RE: Murphy Express – 1358 Wyoming Blvd
Grading Plan
Stamp Date: 01/12/18
Drainage Report
Stamp Date: 01/27/18
Hydrology File: J20D037

Comment Response Letter

To: Renee C. Brissette, P.E. Senior Engineer City of Albuquerque 600 2 nd St. NW Albuquerque, NM 87102	Project Murphy Albuquerque, NM
	Project # 20161221.0
	From Dominic Serra
	Re Grading plan and Drainage Report Comment Response
	Copies 1

GRADING PLAN

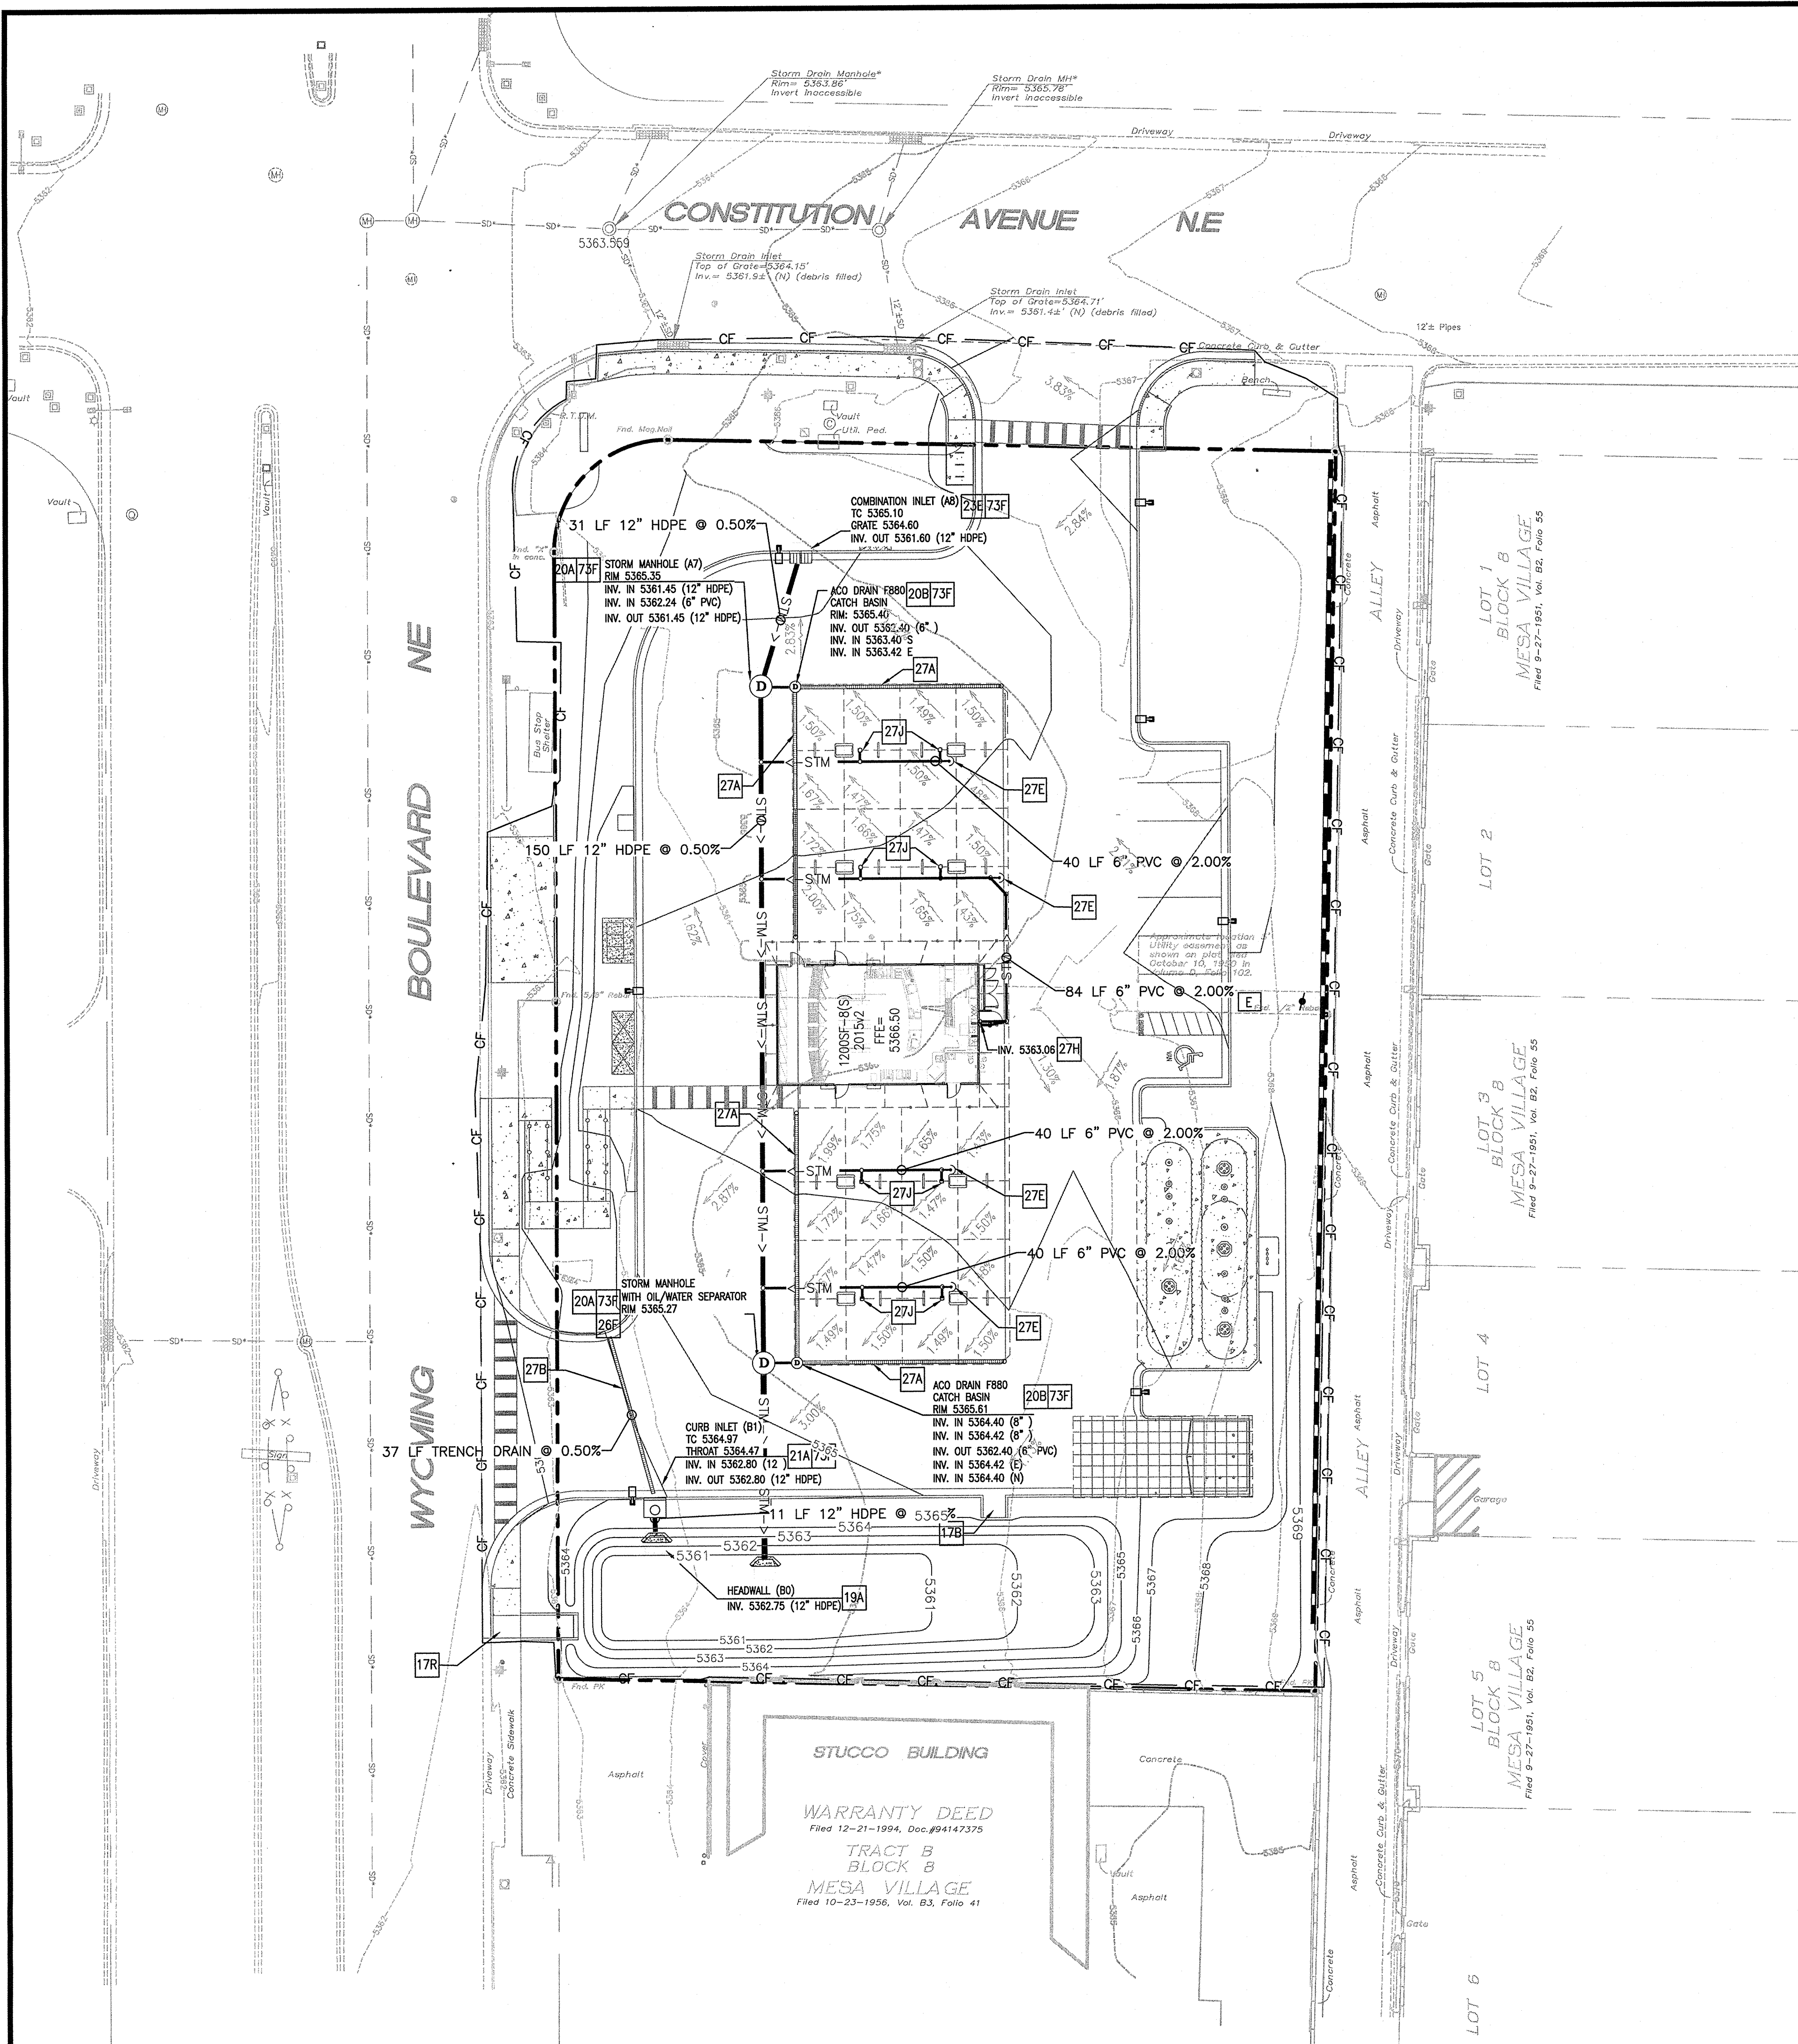
Please Provide the benchmark information for the survey contour information provided.

Response: Benchmark information has been added to the grading plan. See sheet C-3.

Bio Retention Area Plan

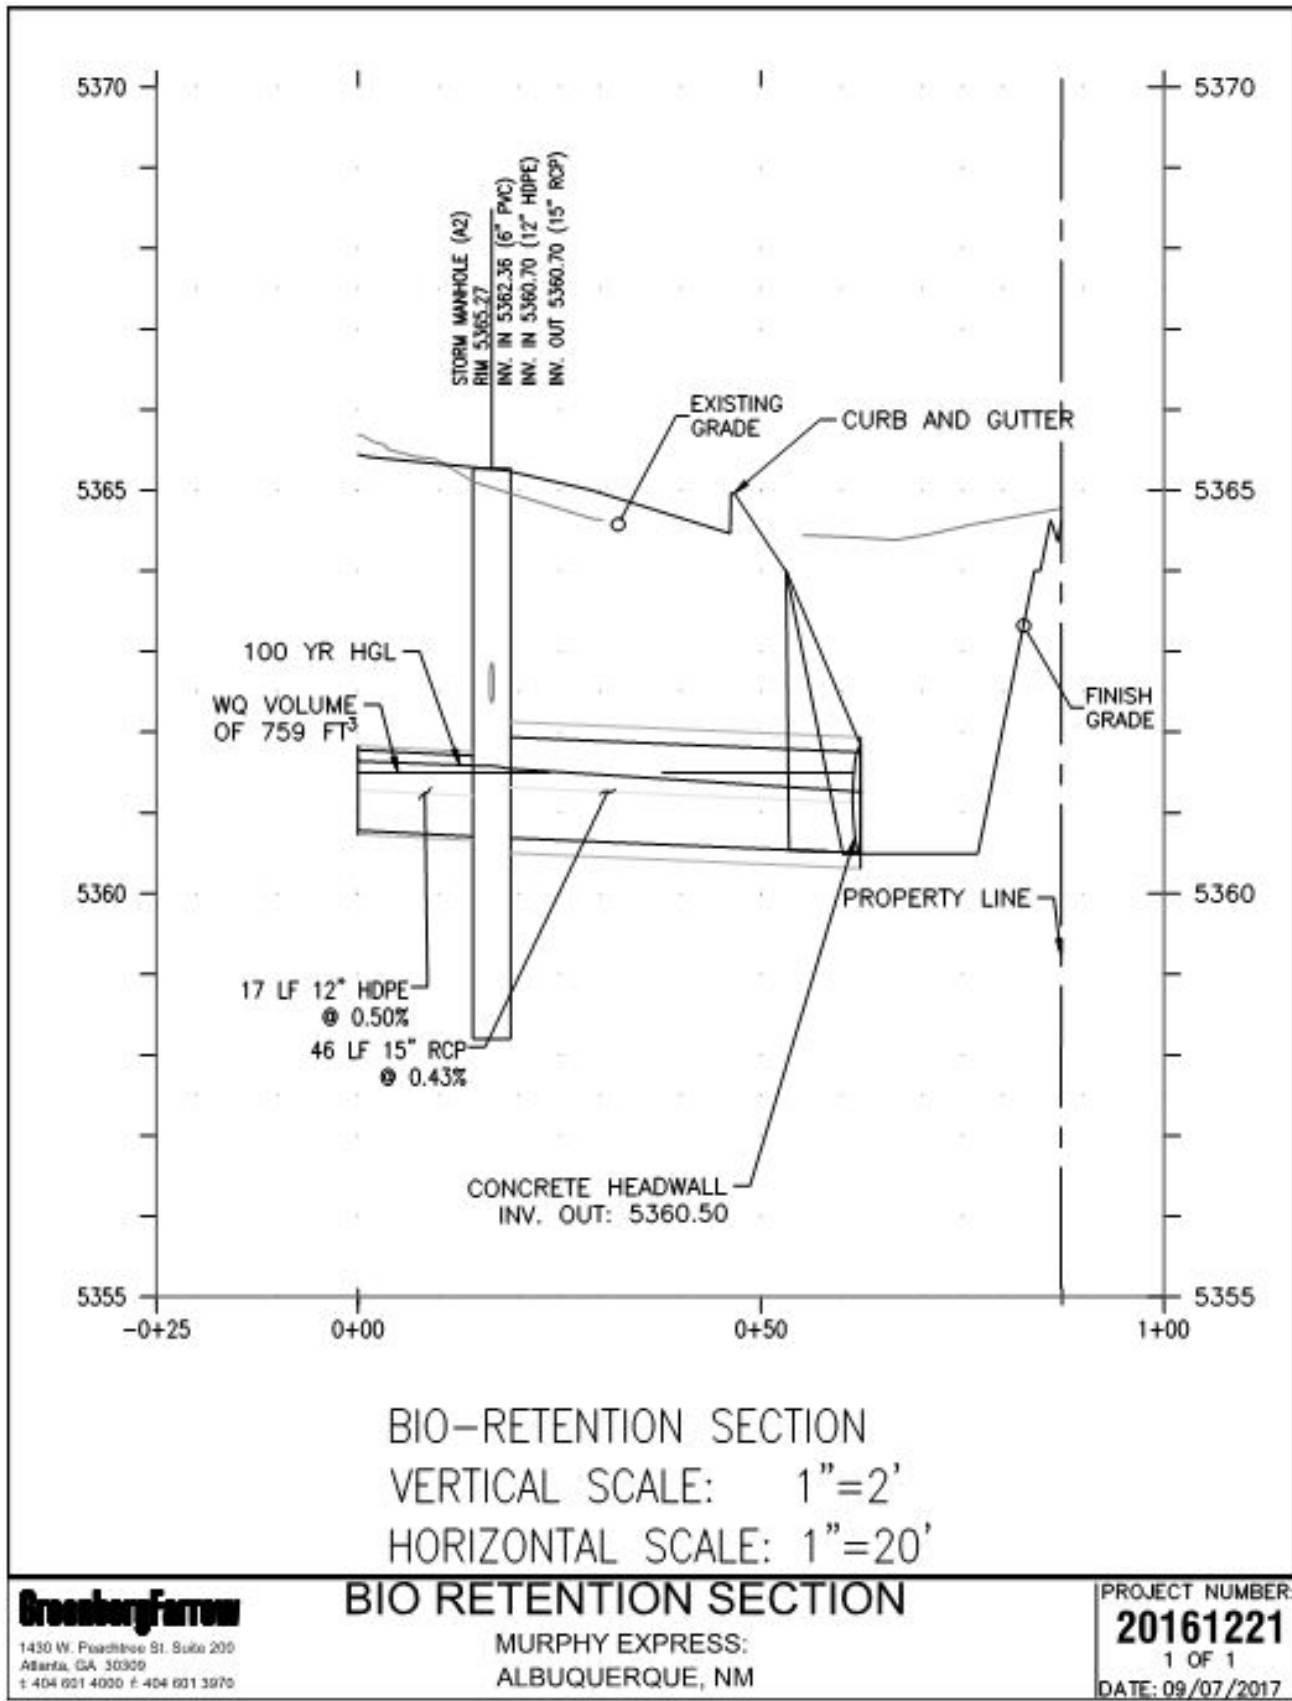
Appendix "A" – Bio Retention Area. Please look into your use of Filtrexx within the water quality pond. Here in Albuquerque, unless this area is going to be irrigated, all water quality ponds are usually graveled. If you want to use landscaping please make sure it fits with xeriscape theme.

Response: The water quality pond WILL be irrigated.
